Date: 07-Apr-2026
Our Ref: 2025/92725

**Application for Approval of Details Reserved by Condition
Town and Country Planning Act 1990
Planning (Listed Buildings and Conservation Areas) Act 1990**

**Discharge of details reserved by conditions 7 (CMP), 8 (CEMP), 9 (road condition survey), 14 (invasive non-native species protocol), 15 (footway spec), 17 (road drainage structures), 18 (surface water spec), 19 (exceedance event), 20 (temp drainage) on previous permission 2022/92406 for erection of 10 affordable dwellings with access from Chapelgate and associated works including resident play zone adj 67, Chapel Gate, Scholes, Holmfirth, HD9 1SX
Application Number: 2025/92725**

Figure 1: Invasive Plant location plan (*Buddleia davidii* not mapped)

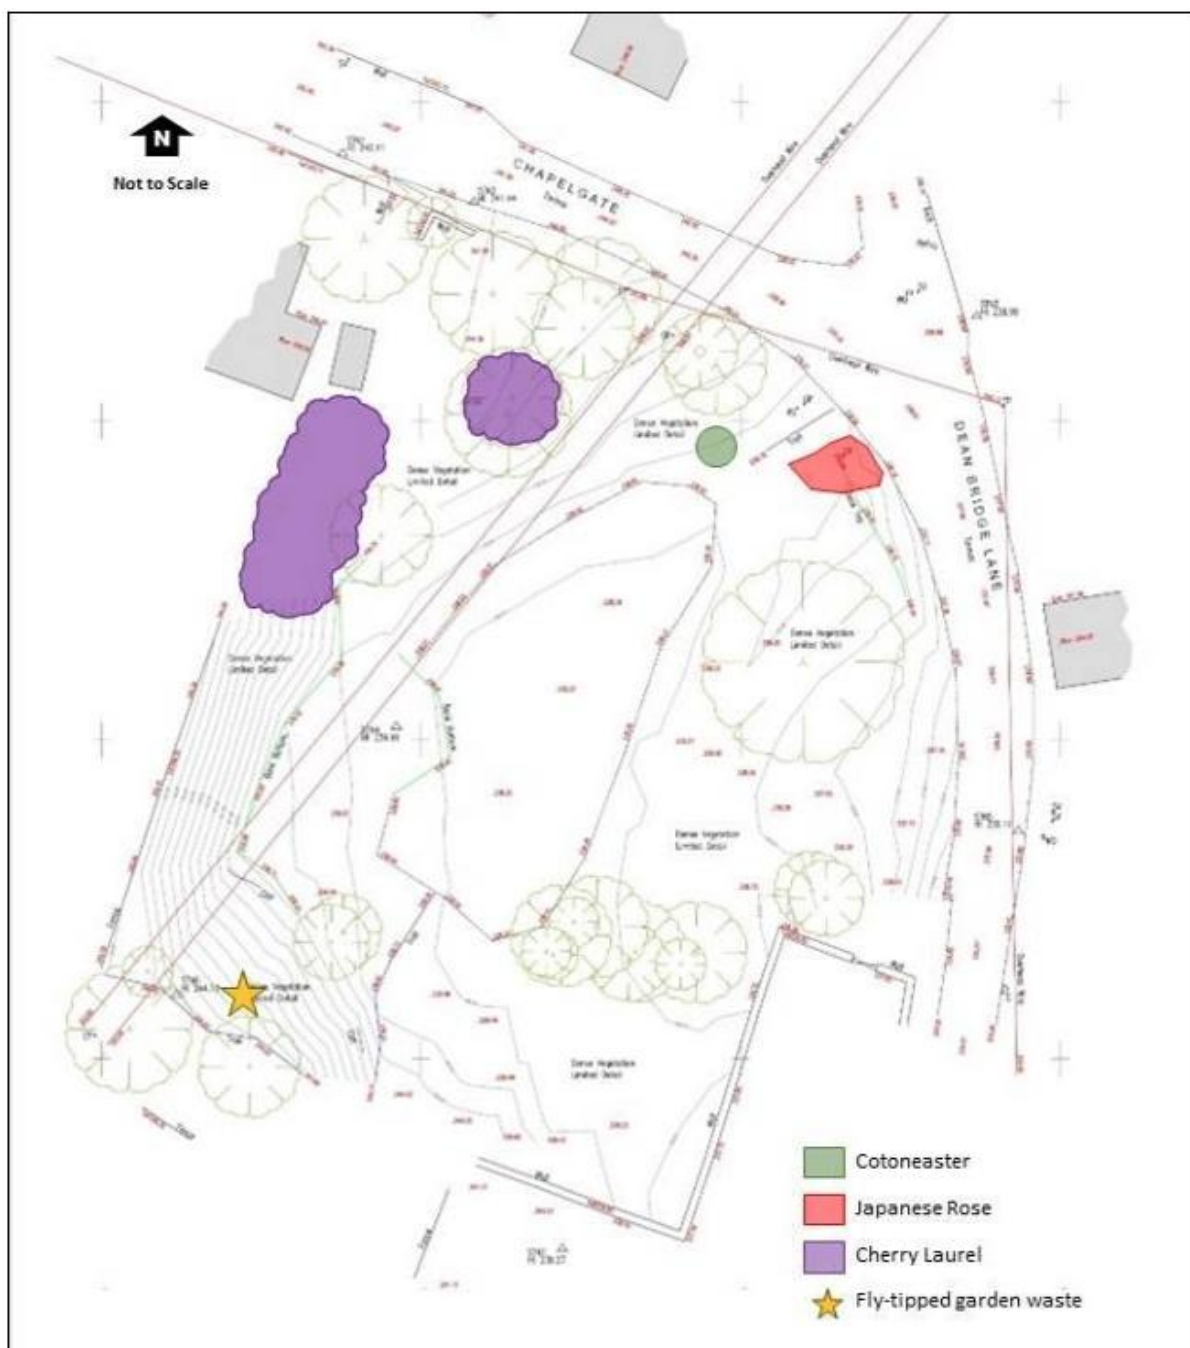
In summary, condition 14 requires consideration of the species “buddleia Buddleia davidii”. This was because it was identified as being present on page 18 of the EclA submitted under 2022/92406. The Invasive Plant Management Plan submitted for this application does not include any information in relation to the species “buddleia Buddleia davidii”, as requested by condition 14. Clarification on this matter is required.

Officers would like to offer six weeks from the date of this decision for you to submit the required information in relation to condition 14 under the current Discharge of Conditions application. Any information submitted after the six week period, would require a new Discharge of Condition application.
